From: Philip Price <Philip.Price@West-Norfolk.gov.uk>
Sent: 18 January 2021 16:00
To: Planning EConsultation <planning.econsultation@West-Norfolk.gov.uk>
Cc: Natacha Osler <natacha.osler@west-norfolk.gov.uk>
Subject: Fw: Planning Application 20/02047/F

Our ref: 21/00249

RE: Replacement of deteriorating timber framed asbestos garage/workshop with timber cabin/studio on existing concrete foundation.

Contaminated Land

B. Pre-existing asbestos/concrete building block plan at Cuckstool Cottage

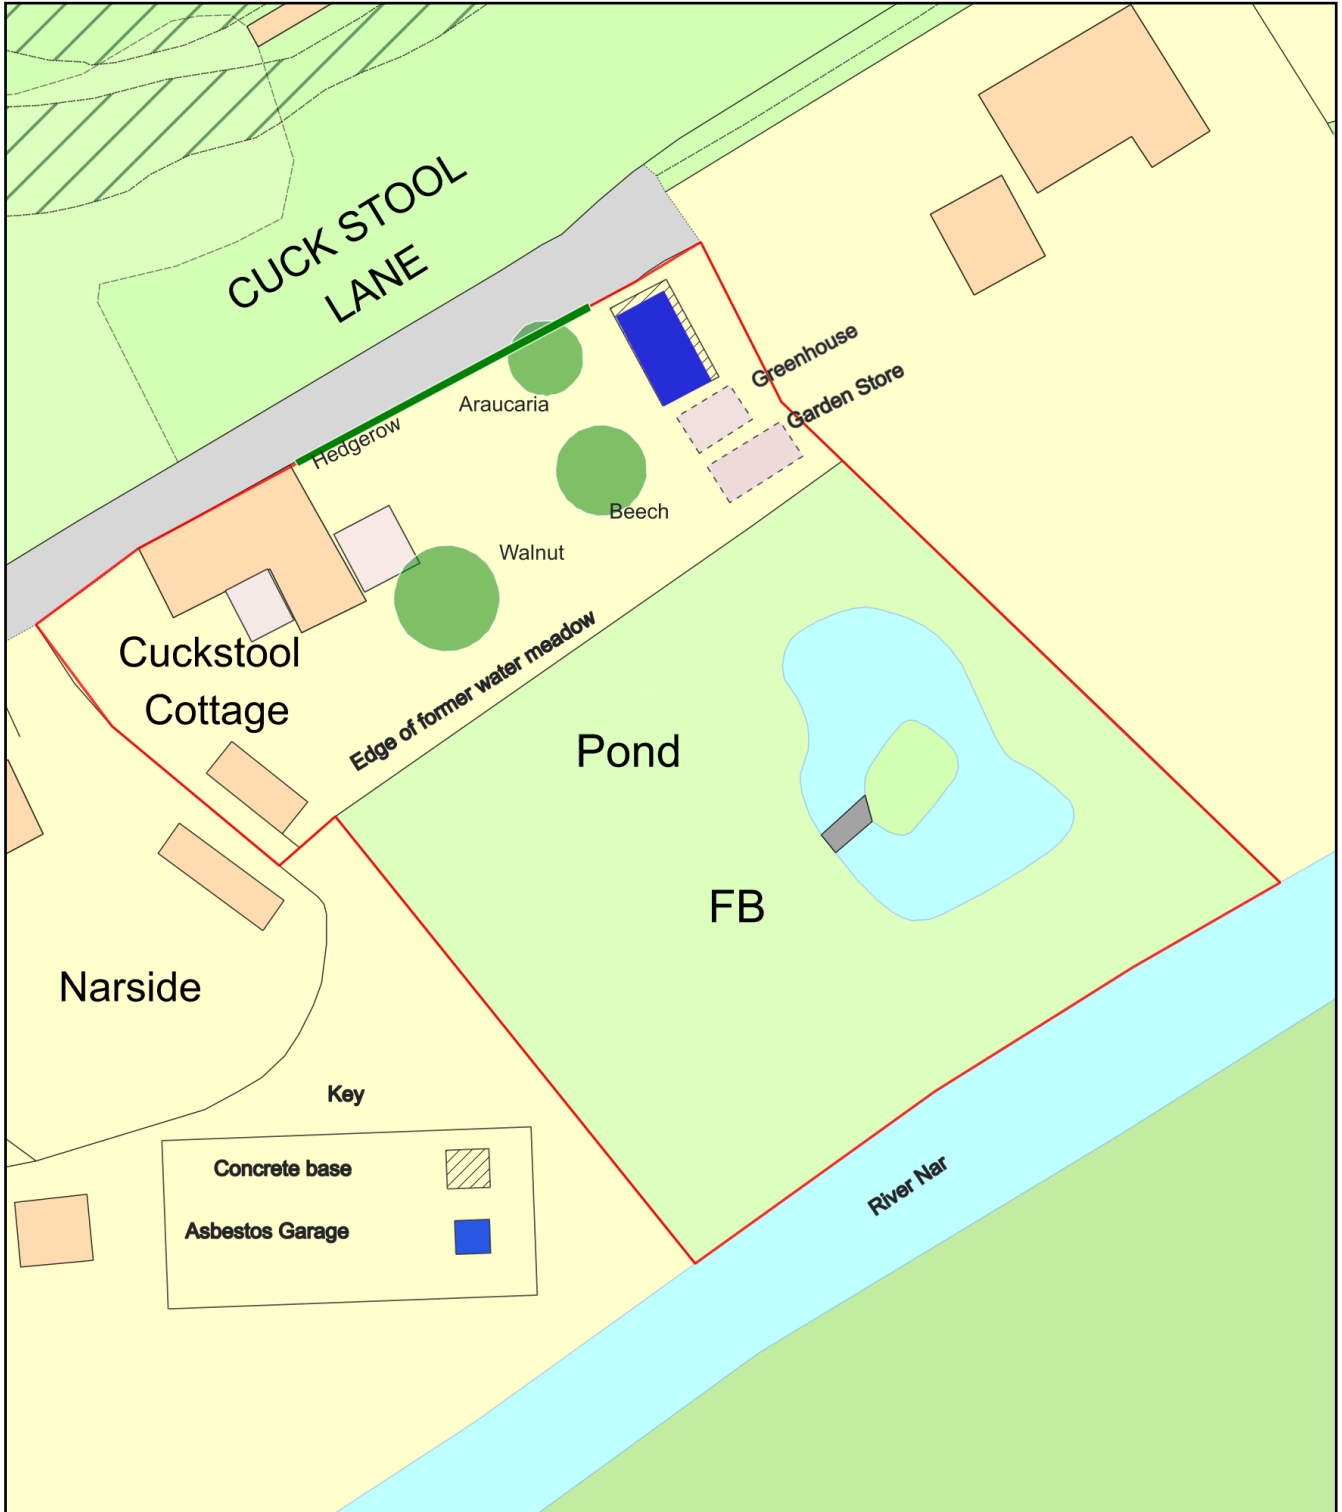
The site is identified as being occupied by a shed suspected of having asbestos containing materials in its fabric. In addition our files indicate potential ground gas sources in the vicinity of the site. The mapping also identifies a lime pit and lime kiln close to the site giving rise to potential contamination.

Given these potential sources of contamination, we recommend the following conditions:

- 10009 – site characterisation
- 10010 – submission of remediation scheme
- 10011 – implementation of approved remediation scheme
- 10012 – reporting of unexpected contamination
